Subject: RE: BN/32/17/DOC - Condition 12 Play Equipment - Former Pollards Nursery site, Lake Lane, Barnham

Further to the submission of the following drawings in relation to Play, I have the following comments to make:

Client:	Redrow Homes Southern Counties	Scale:	1:500@A1
Project:	Pollards Nursery, Barnham	By/Chk:	LM/JH
Drawing Title:	General Arrangement Plan	Date:	09/11/16
Sheet	1 of 2		
Drawing Number:	2600-LA-13	Revision:	P9

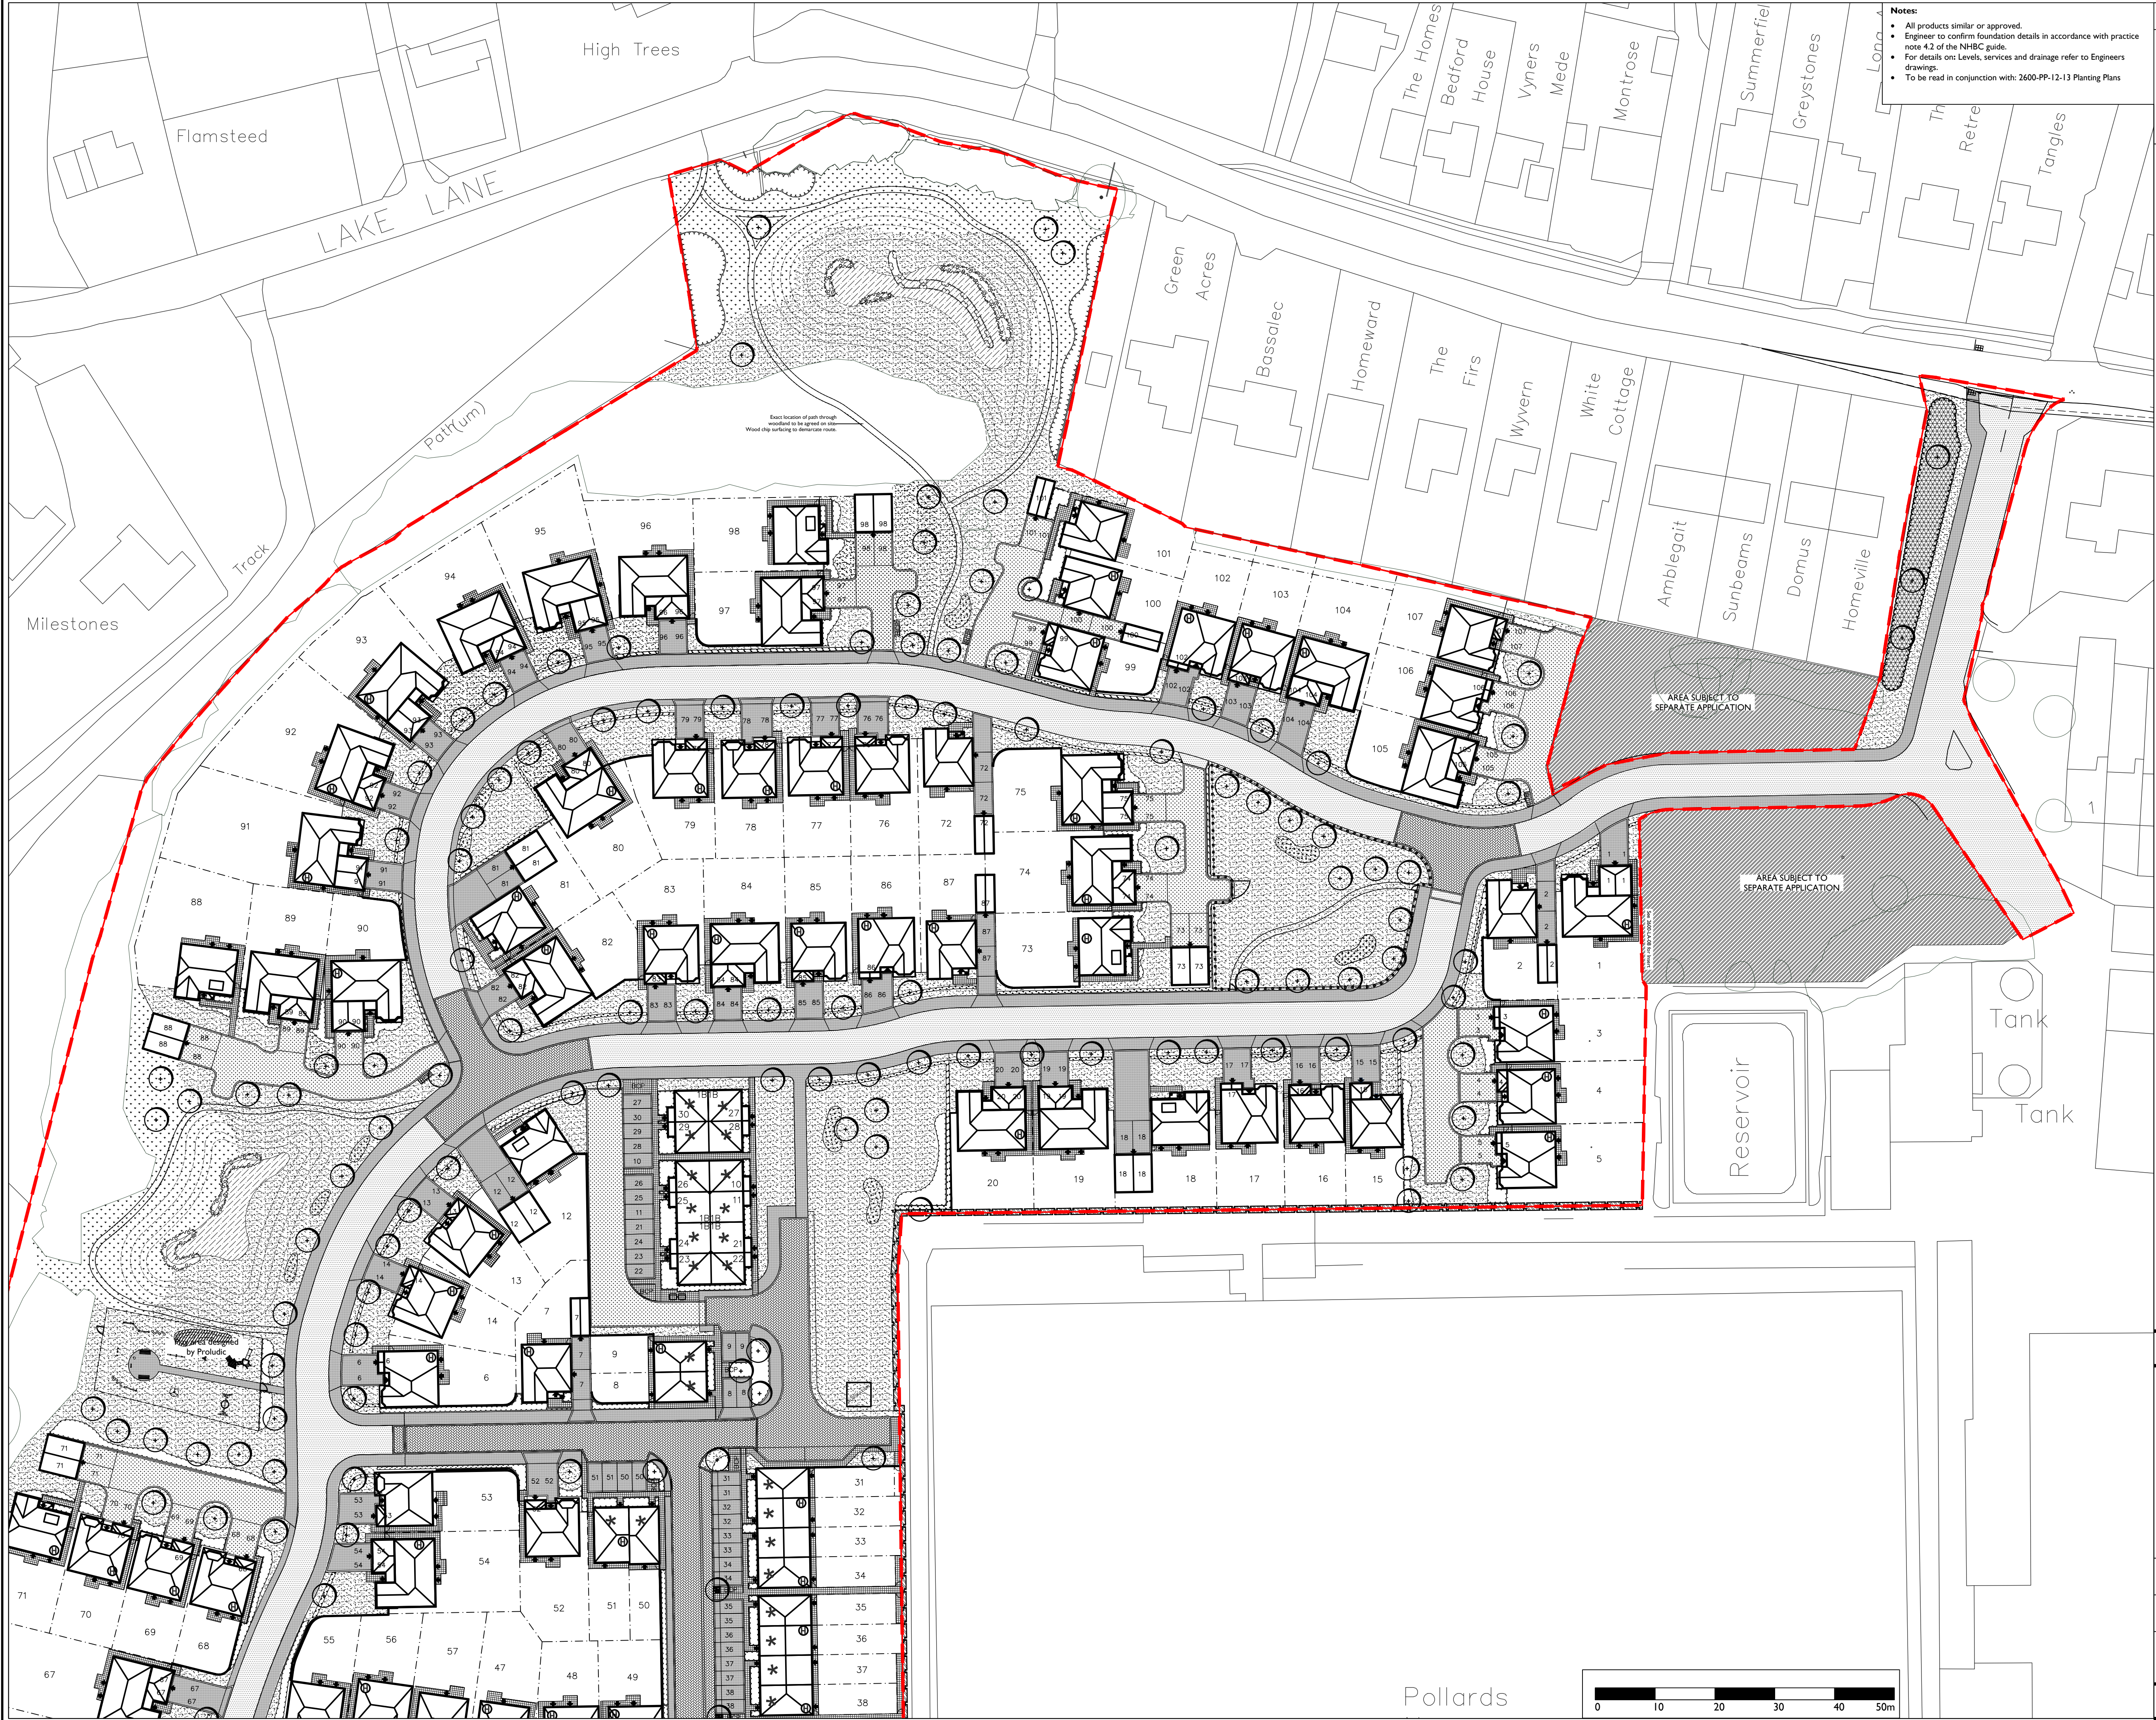
- I would also make an advisory note that the siting of the play area is within the recommended 20m buffer with the property shown as Plot 6 and again on the very border of the buffer with the properties to 68-71 to the south.

- The gate shown to the east of the play area appears to have no connection to any external pathway which would be required in order to make this accessible and usable to all, all year round.
